Application for removal or variation of a condition following grant of
planning permission. Town and Country Planning Act 1990.
Planning (Listed Buildings and Conservation Areas) Act 1990

House:		Suffix:	
House name:	Lefleys Garage		
Street address:	Station Road		
	Holbeach		
Town/City:	Spalding		
County:	Lincolnshire		
Postcode:	PE12 7LF

Change of use of site to Class C3 (residential), erection of 51 dwellings and conversion of Station House building to 4 dwellings.

Project:			
Former Garage & Public House Site			
Station Road			
Holebeach			
Lincs			
Drawing Title:			
Proposed Renewable Energy			
Client:			
Haycroft Homes Ltd			
Drawn:			
AMW		Checked:	AMW
11/12/2022		Date:	24.10.13
PD24		Stage:	As shown
P2		Revision:	A1

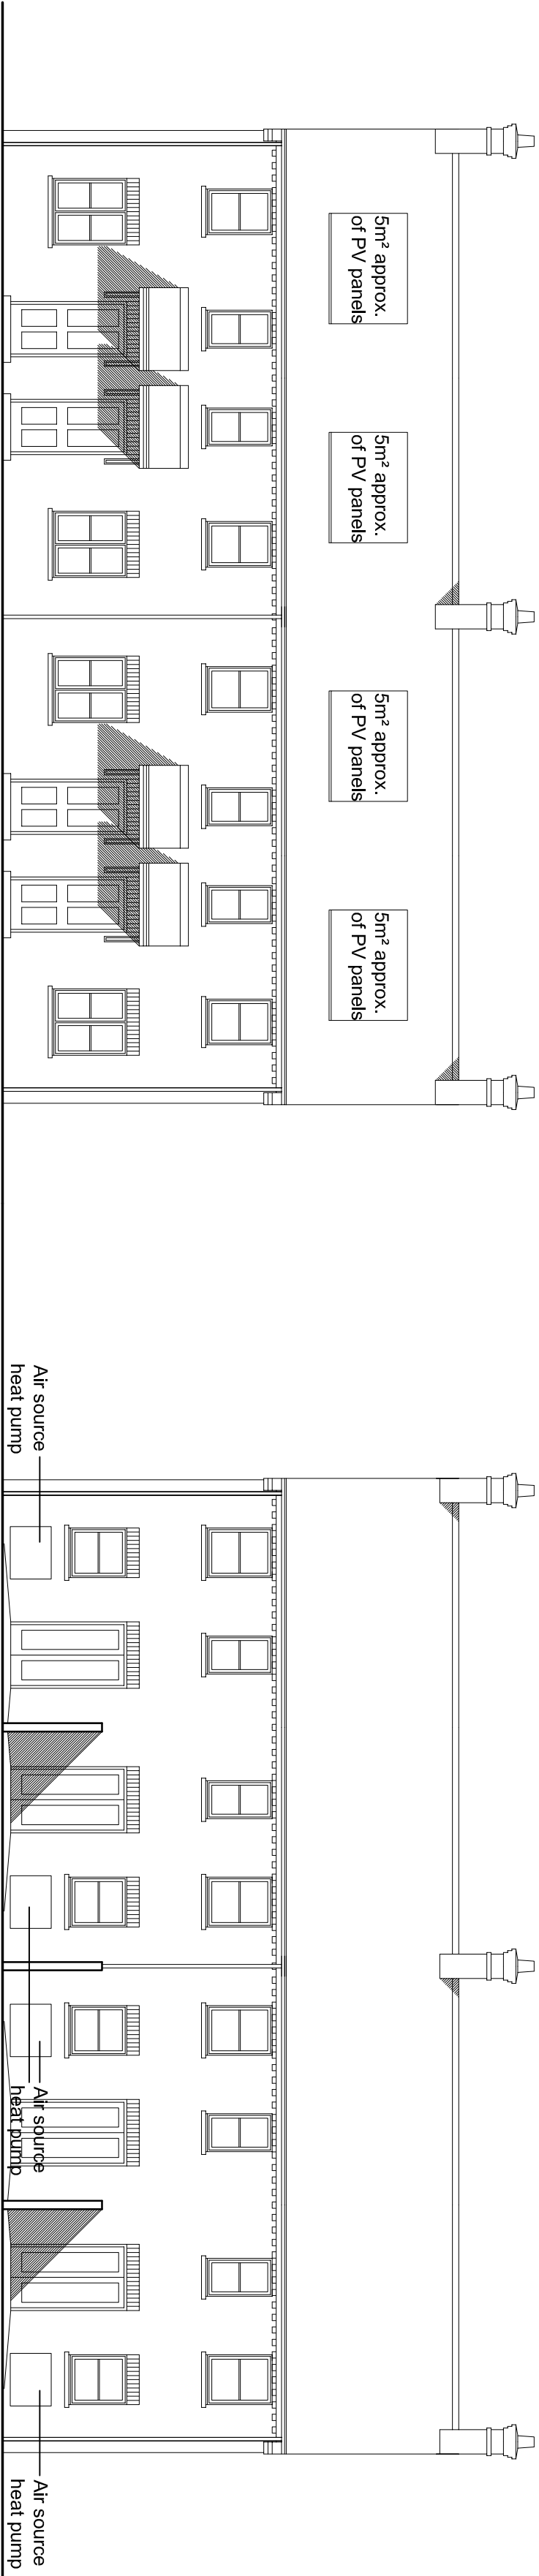
It is requested that condition 2 is changed to include drawing number PD24(P2).

This is because the renewables scheme has been revised following the previously submitted / approved scheme under H09-0962-13.

Please list/include drawing number PD24(P2) in condition 2 as an approved plan.
